Application for Consent to Display an Advertisement(s)

Development: Retention of 1 No non illuminated free standing town boundary sign.
Location: Highway Verge Between Hawthorn Road And Aldwick Road Bognor Regis

AREA 2 HA
SCALE 1:1250
Aldwick Road & Hawthorn Road – location plan
CENTRE COORDINATES: 492029, 99270

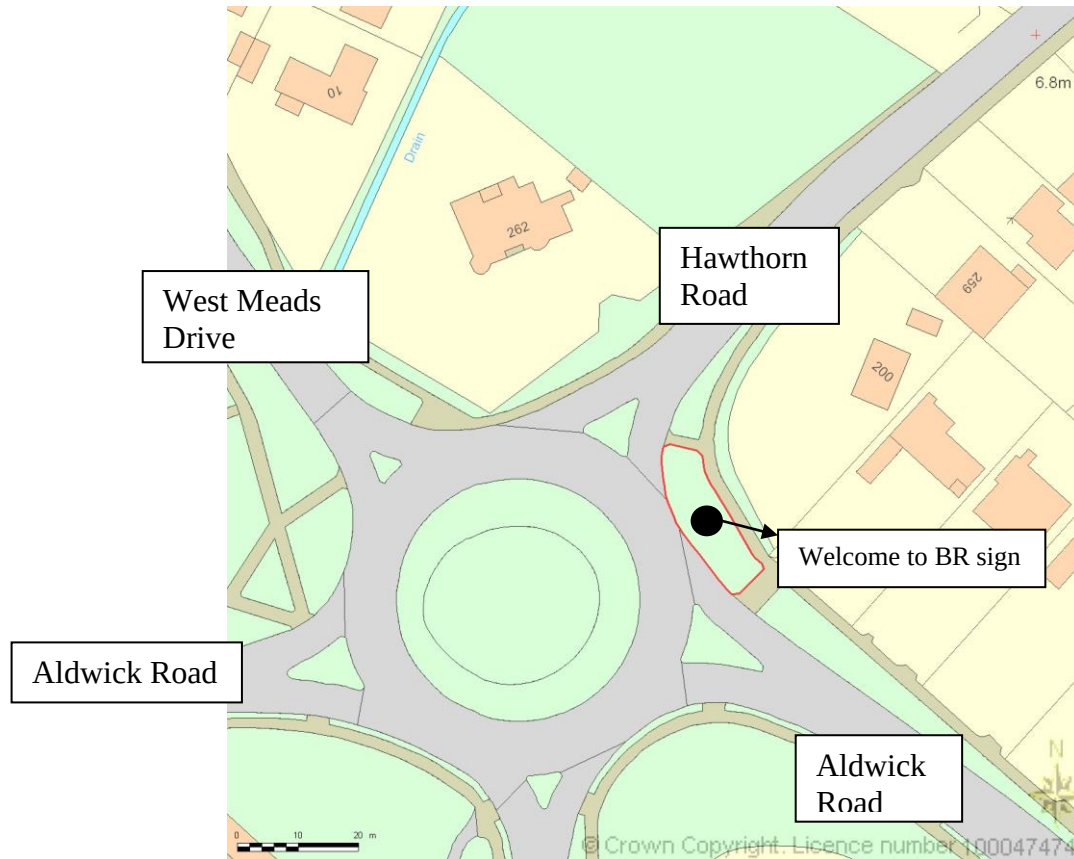
Location Plan

Please provide one named road.
